from
**Southern
Water**

Your ref
Y/70/19/HH

Our ref
PLAN-029620

Proposal: Extension to front elevation & conversion of existing rear conservatory.
Site: Y/70/19/HH: - 28, Downview Road, Yapton, BN18 0HJ.

Ground Floor Plan ~ As Proposed

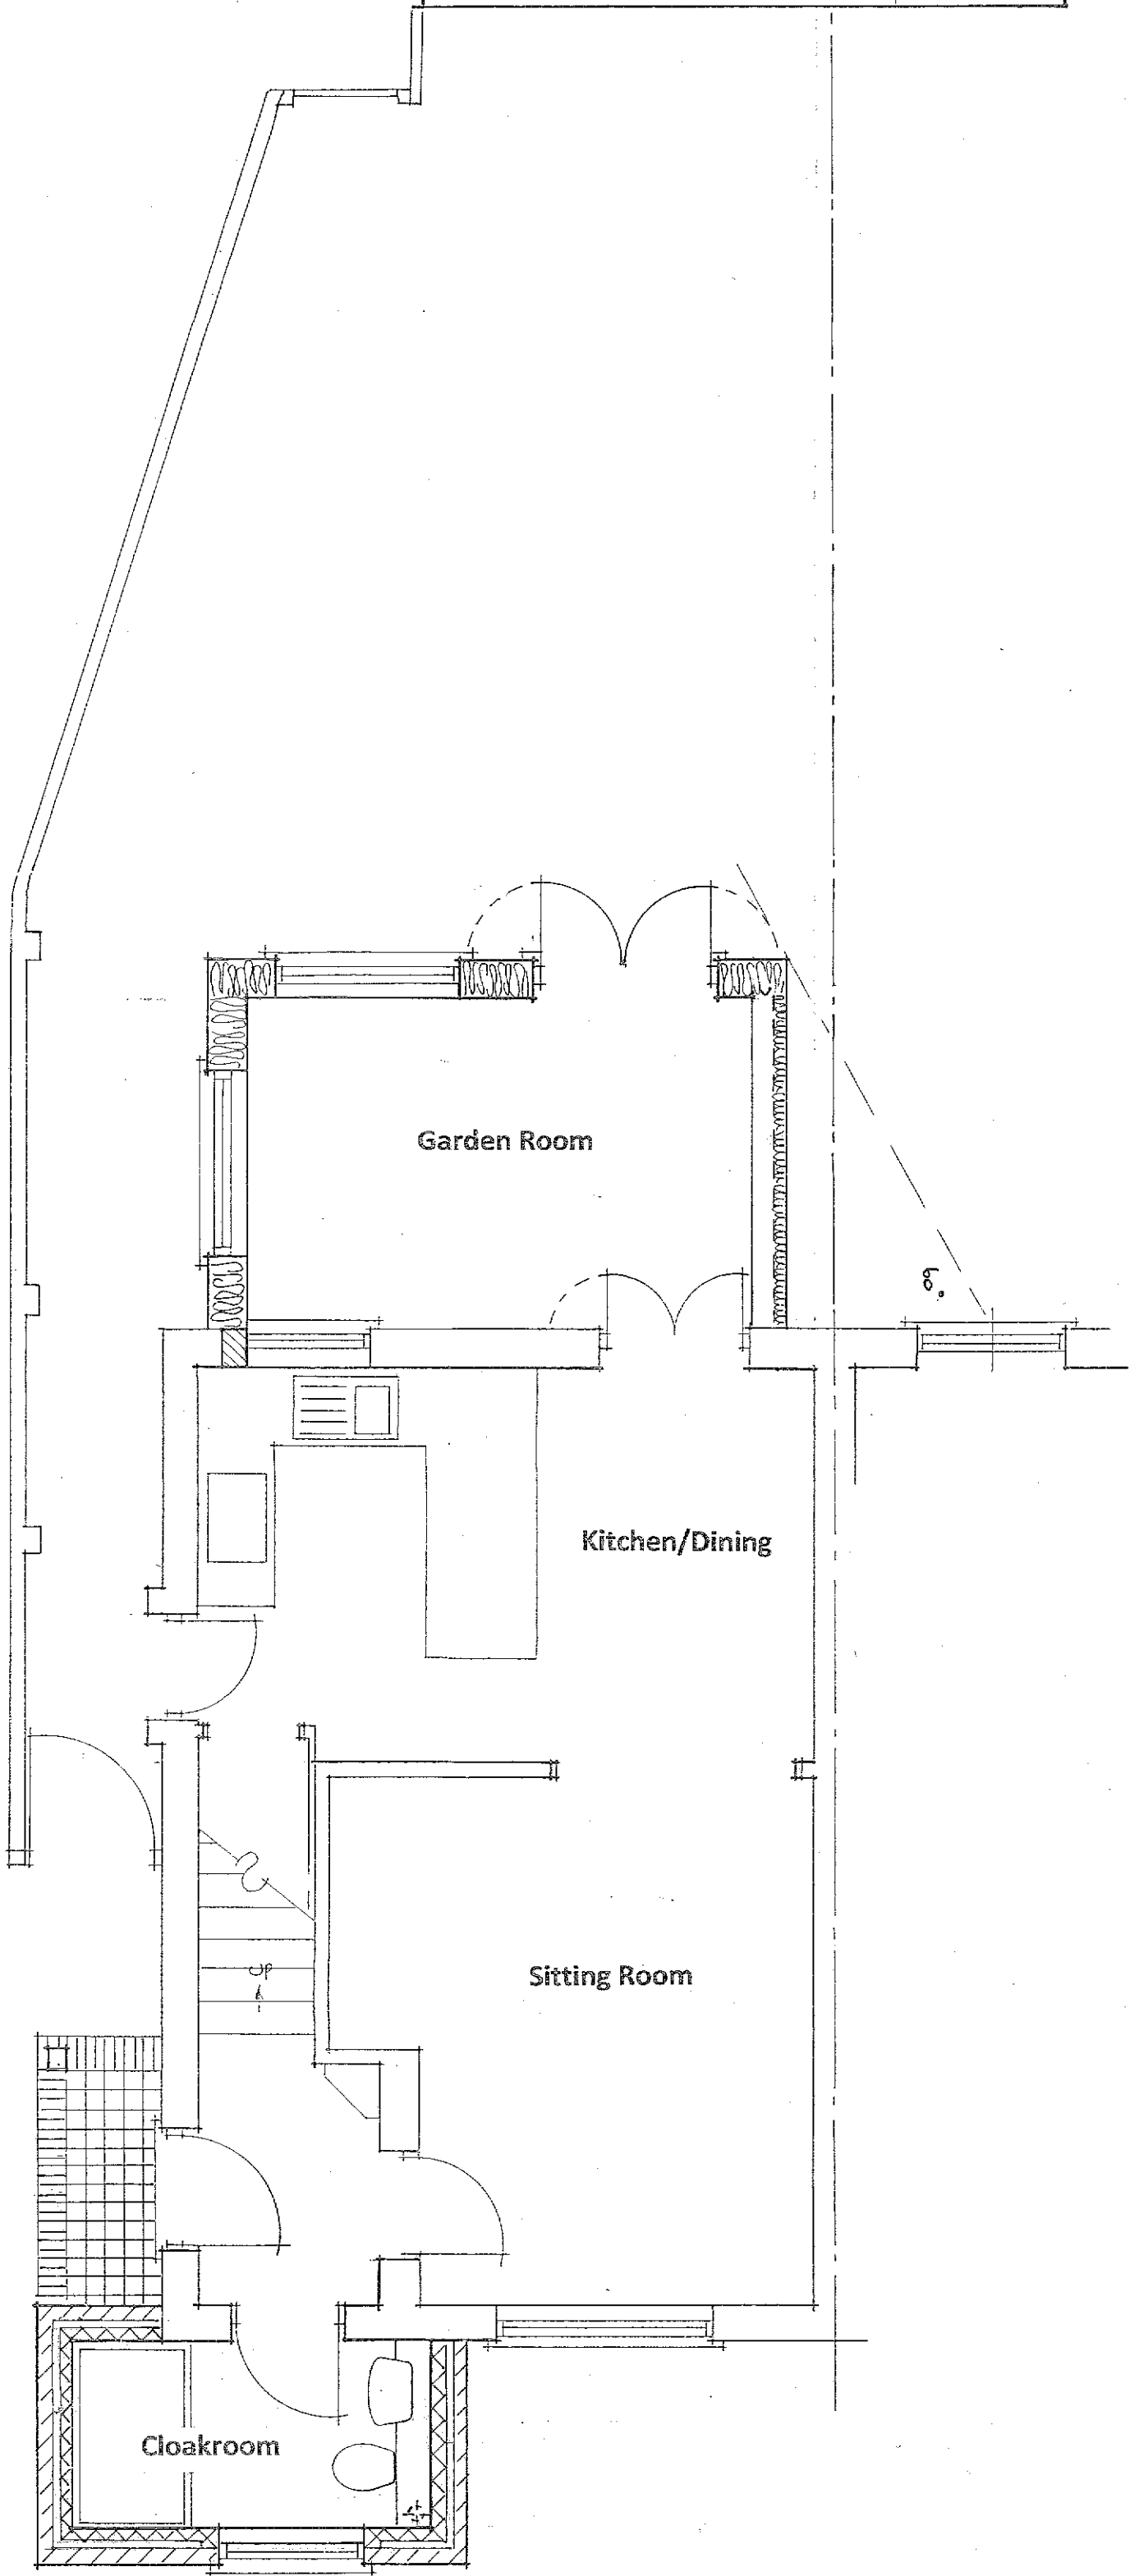
It appears that the developer is intending to build over to a public foul sewer which is crossing the site. Building over a "public sewer" is not normally permitted by Southern Water.

However, under certain circumstances building over a sewer may be allowed. The conditions associated with the build over a sewer are contained in Southern Water guidance notes which are available at: www.southernwater.co.uk. A formal application to build over to the sewer will required to be submitted by the applicant.
